Town & Country Planning Act 1990 (as amended)
Town & Country Planning (Development Management Procedure) (England) Order 2015
Application for Planning Permission for Works or Extension to a Dwelling

Development Two storey front extension, two storey side extension and single storey rear extension
Location Stanwick Northfields Lane Westergate

I regret that I am unable to accept your documents as a formal application until the following item(s) have been received or resolved :-

Block Plan 1:500

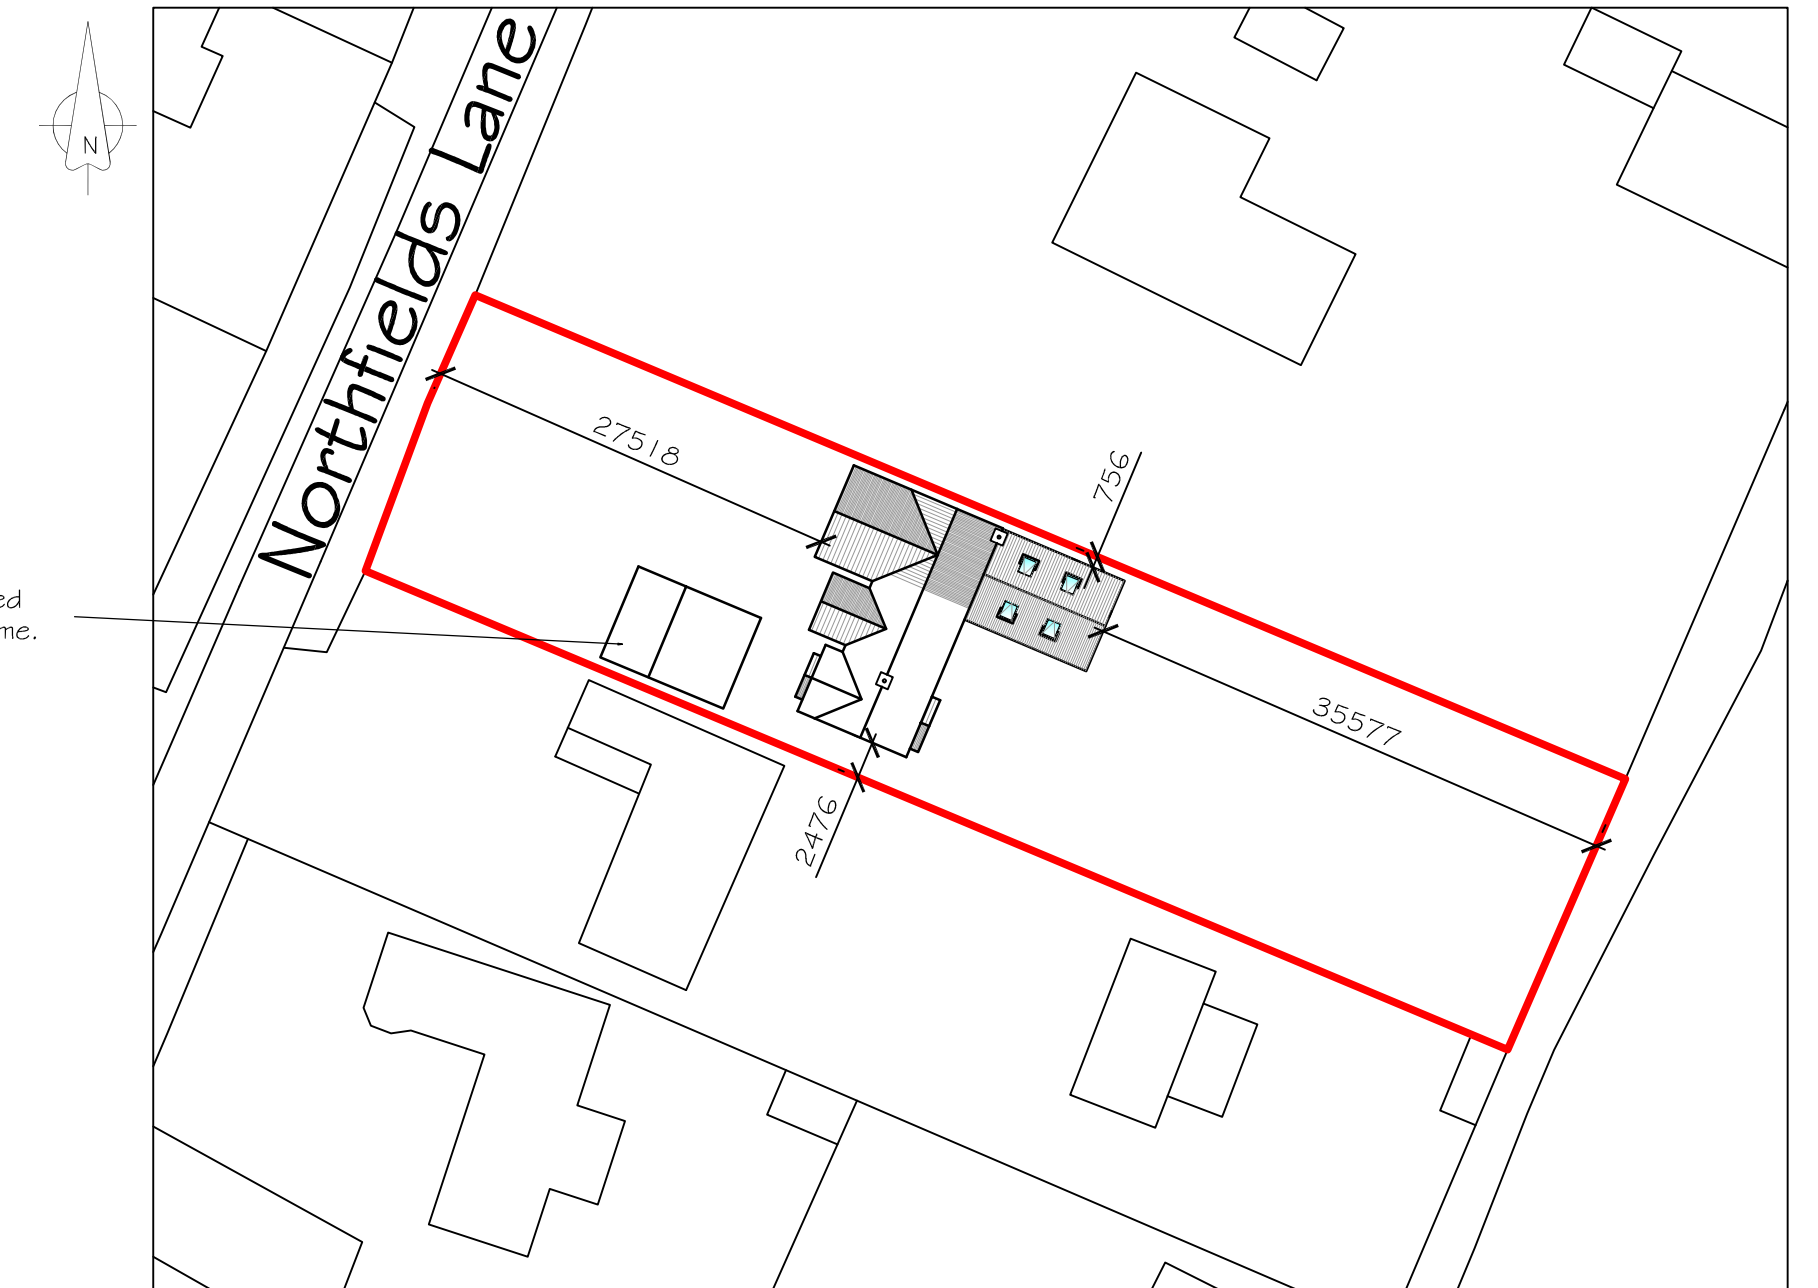
Please include dimensions from all your extensions to all site boundaries on the block plan.
